**Beaches Yard,  
Horton Road,  
West Drayton**

**Prepared for  
Harvest Land Management**

**SMA Ref: 6969/TAA**

DOCUMENT CONTROL			
Project	Beaches Yard, Horton Road, West Drayton		
Job No.	6969		
Document Title	Transport Assessment Addendum		
File Location	\Smadata\data2\Admin Project\6900 to 6999\6969 - Warehouse near Heathrow\Reports		
Prepared by	Rhys Donoghue	Date	20/02/2023
Reviewed by	Rhys Donoghue	Date	21/02/2023
Approved by	Dave Wiseman	Date	21/02/2023
Document Issue	Description / Changes	Revised by	Date
01	Issued for Client Review	RD	21/02/2023
02	Revised as per Client Comments	RD	24/02/2023
03	Minor Revisions to Report	RD	24/02/2023

DATE	AUG 22	DRAWN	RD	CHECKED	DLW	ISSUE	CHECKBOX
DRAWING No.	6969.001	REV	C	SCALE	1:500	@	A3

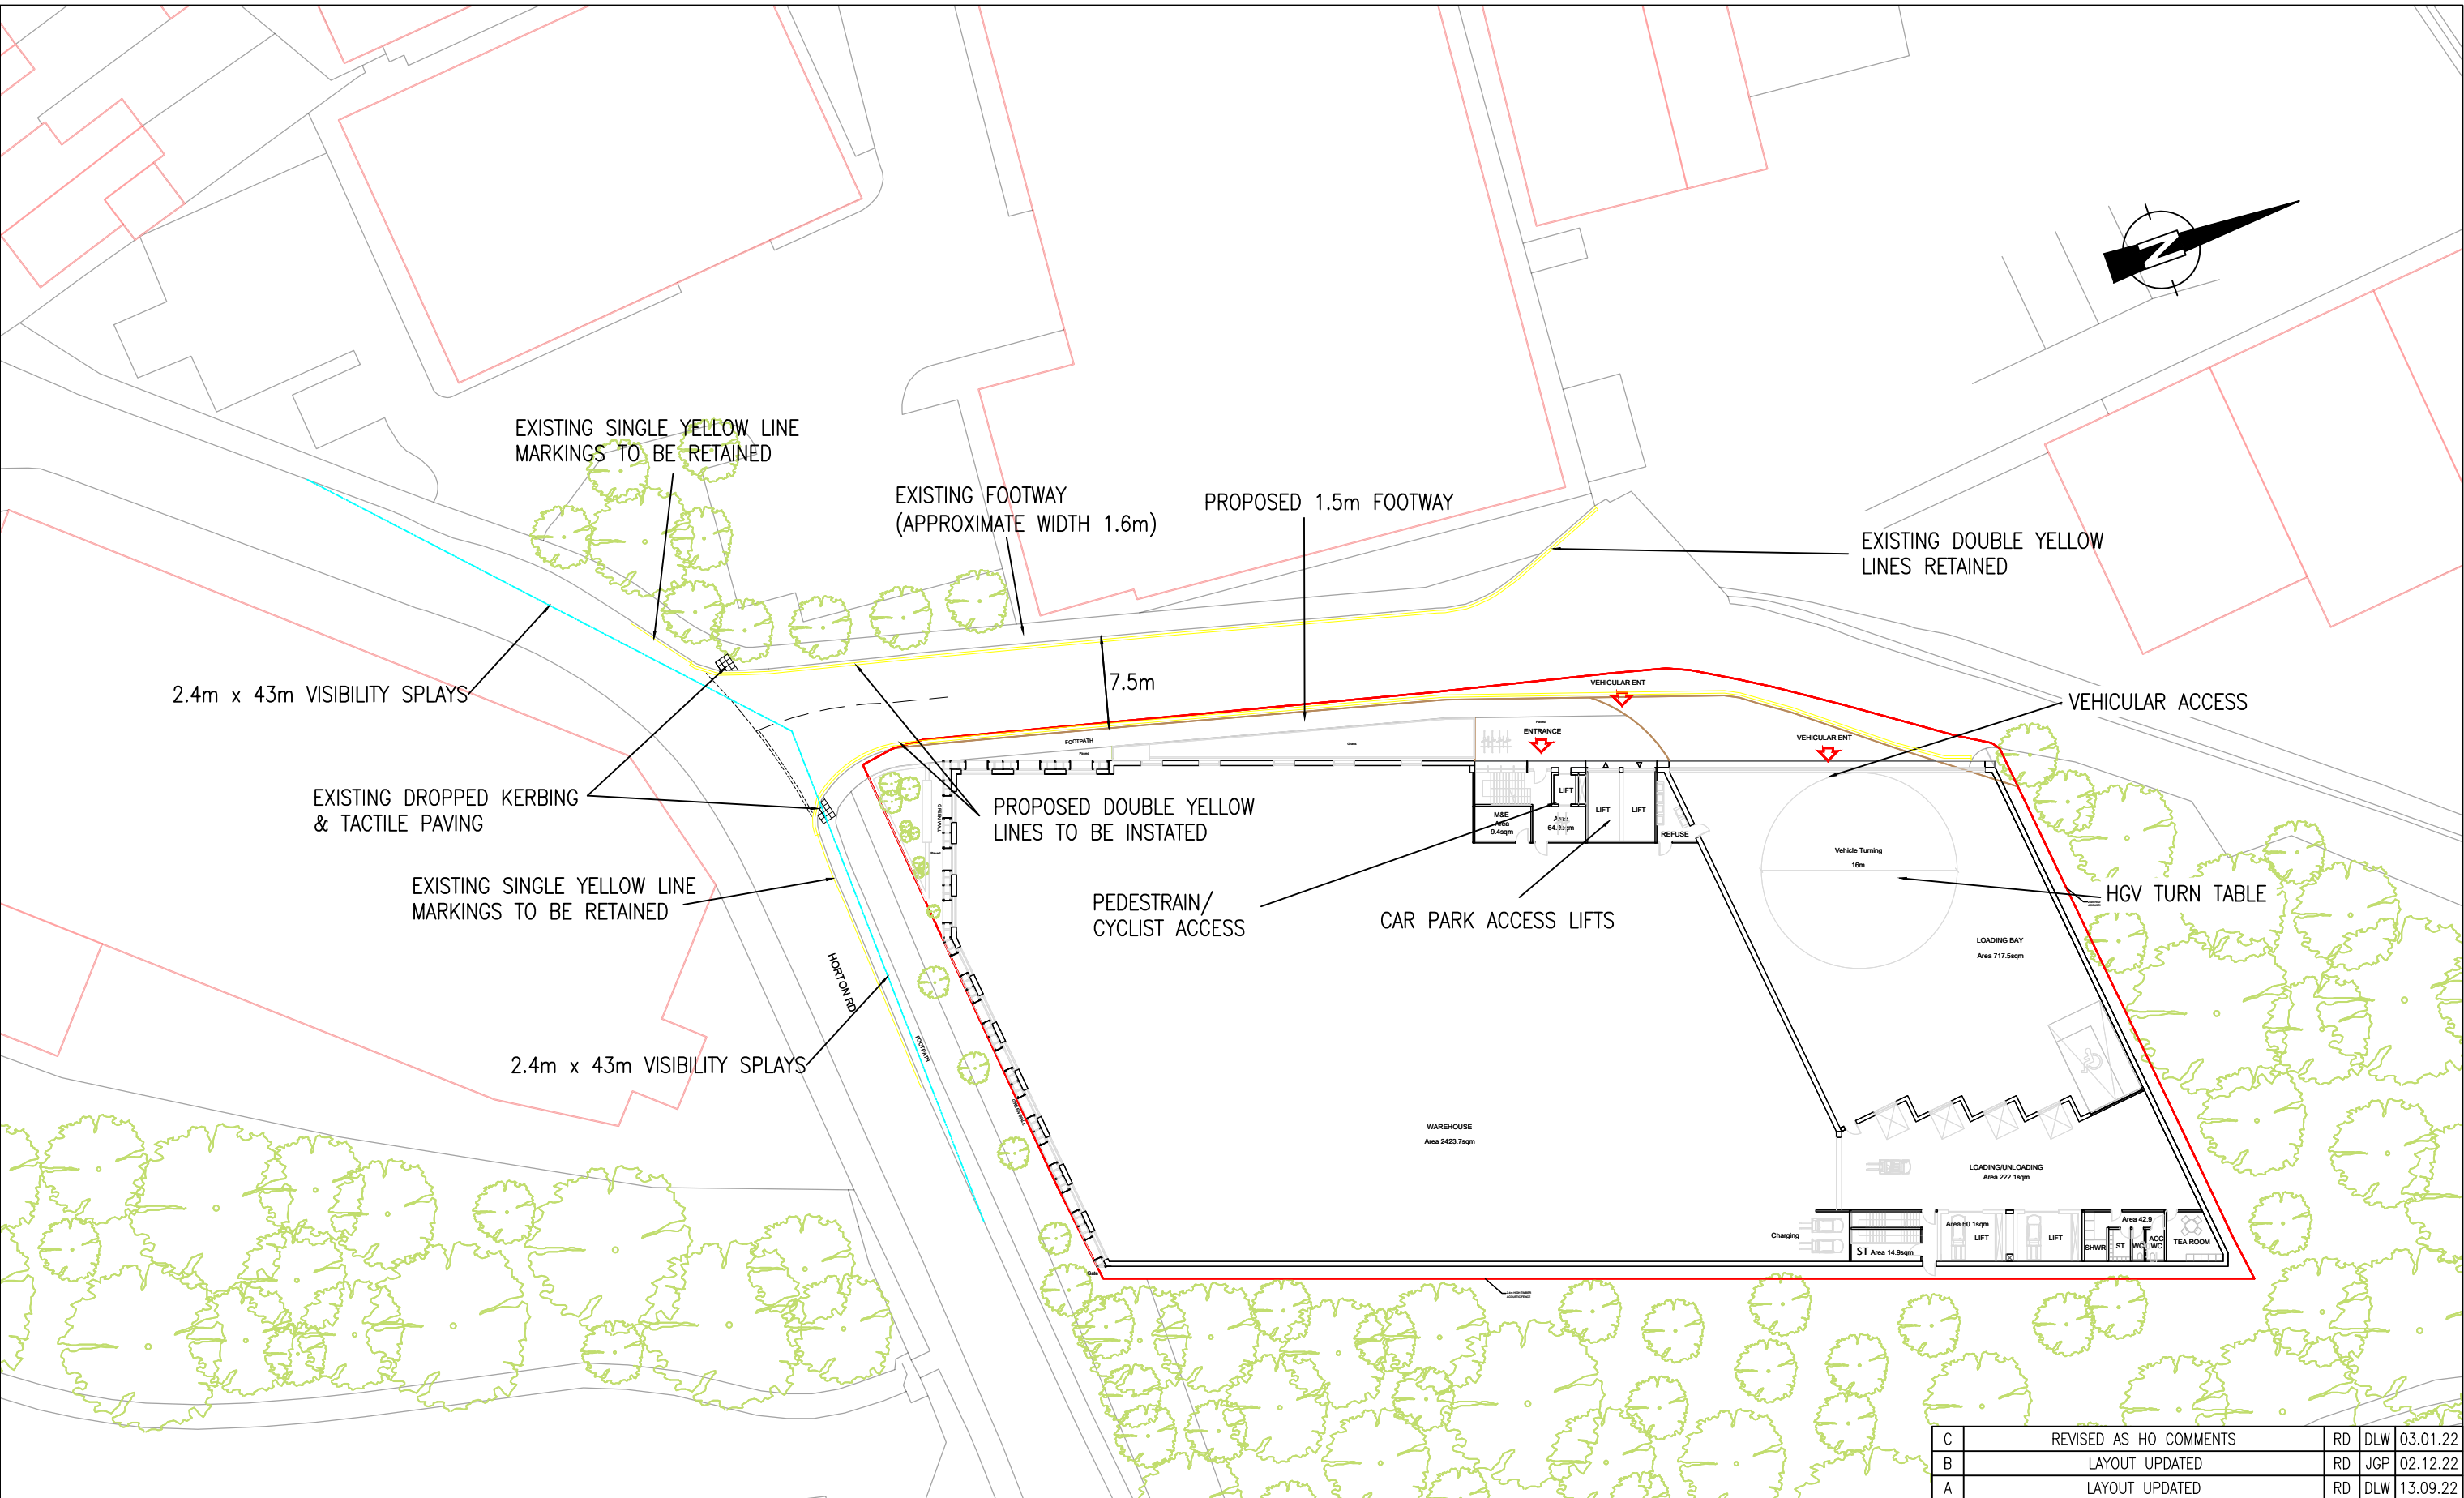
Amended plans now indicate that the private road outside of the development are within the applicant control through the new red boundary line that is seen on plans. It is good to see that some enforcement will be made by preventing cars from parking on the road through the installation of double yellows. Nevertheless, the Highway Authority would require that more improvements be made to the road that would improve road safety and make it more suitable for HGV use. It is noted that the footpath will be widened on the side of the development, though this does not lead anywhere for pedestrians to go. Furthermore, nothing has been proposed to restrict vehicles from exiting both the basement car park and loading bay that ensures that drivers check to approaching vehicles. Finally, the Highway Authority would require that the applicant demonstrate how further improvements can be made to the road which increase road safety. This contradicts the published London Plan 2021 Policy T4 Assessing and mitigating transport impacts which states that '*development proposals should not increase road danger*'.

The Highway Authority would require that all pedestrian access into the basement car park be moved onto Horton Road or internally. This would negate the need for a footpath when the road is already narrow and would mean that pedestrians do not interact with entering/exiting vehicles.

2.11 A black and yellow rubber speed ramp will be provided on exit of the vehicle ramp, to slow cars leaving the car park. Additional STOP road marking will also be provided to stop cars encouraging onto the footway. Bollards will also be provided to ensure that cars do not mount the kerb.

2.12 The HGV access will have STOP markings on exit of the site. Bollards will be provided to ensure HGVs stay within the access area.

2.13 The proposed measures are shown on **Drawing 6969.001F**. The indivisibility between cars and HGVs entering/ exiting the site is shown on **Drawing 6969.012**.

2.15 To ensure the safety of pedestrians on Horton Road and those crossing the junction with the access road, it is proposed that access road is widened and the road markings are realigned to better suit the widened access. The proposed widening and line markings are shown on **Drawing 6969.001F**. Autotrack Swept Paths for a range of vehicles at this junction are shown on **Drawing 6969.002F** and **6969.003F**.

2.16 The development proposes the provision of double yellow lines on the private access road. Currently vehicles park on this section of road, but SMA understands they are vehicles owned by the current land owner.

DATE	AUG 22	DRAWN	RD	CHECKED	DLW	ISSUE CHECKED	
DRAWING NO.	6969.002	REV	B	SCALE	1:500		A1

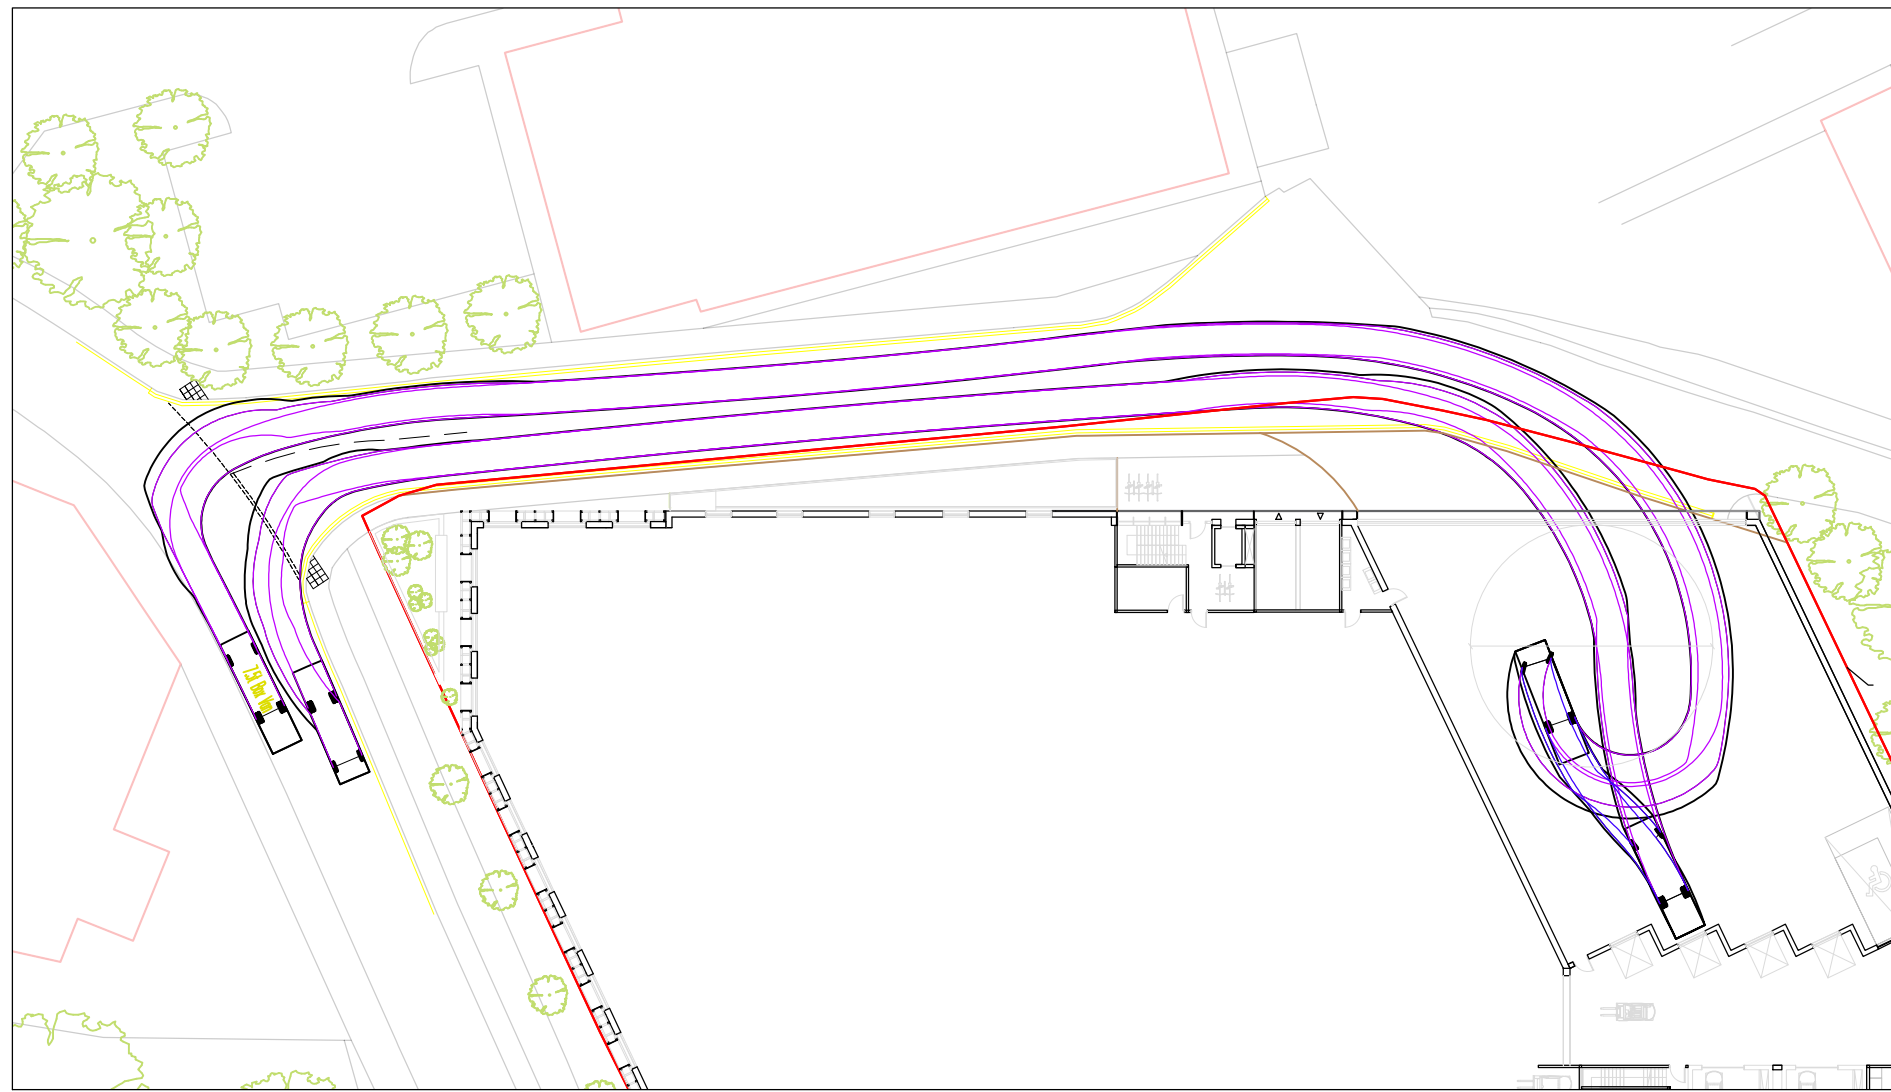
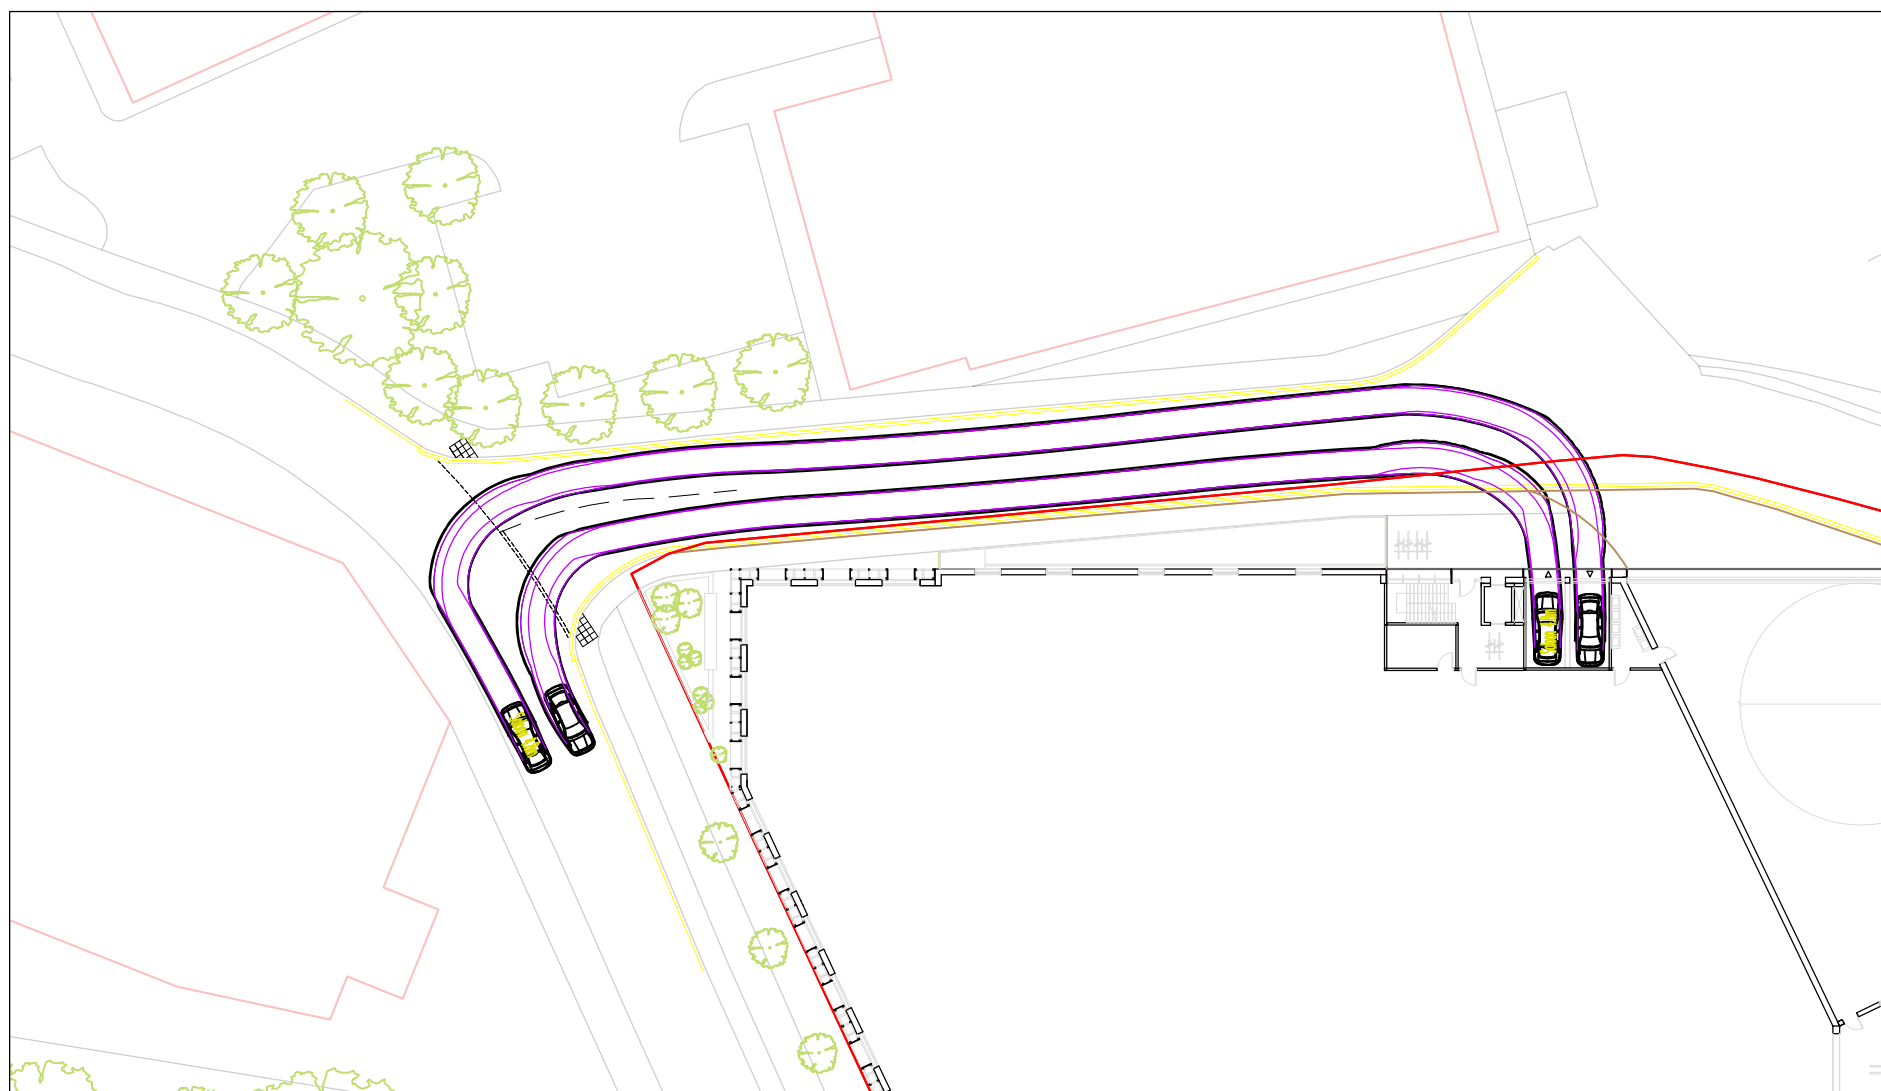
As mentioned above the loading bay will include a vehicle turntable which will rotate the HGVs within the site. There is still the high risk that this can malfunction which will lead to vehicles being unable to turnaround within the development. HGVs should be able to turn on plot without the necessity of machinery, as HGVs are the fundamental use of the site. The Highway Authority will be unable to support any application that sees the implementation of a vehicle turntable. Swept path drawings have been again submitted, though they still indicate that HGVs turning left from Horton Road onto the private road would be very close to the footpath and over sweeping it. This contradicts the published London Plan 2021 Policy T7 Deliveries, servicing and construction which states that development proposal for new consolidation and distribution facilities should '*reduce road danger, noise and emission from freight trips*'.
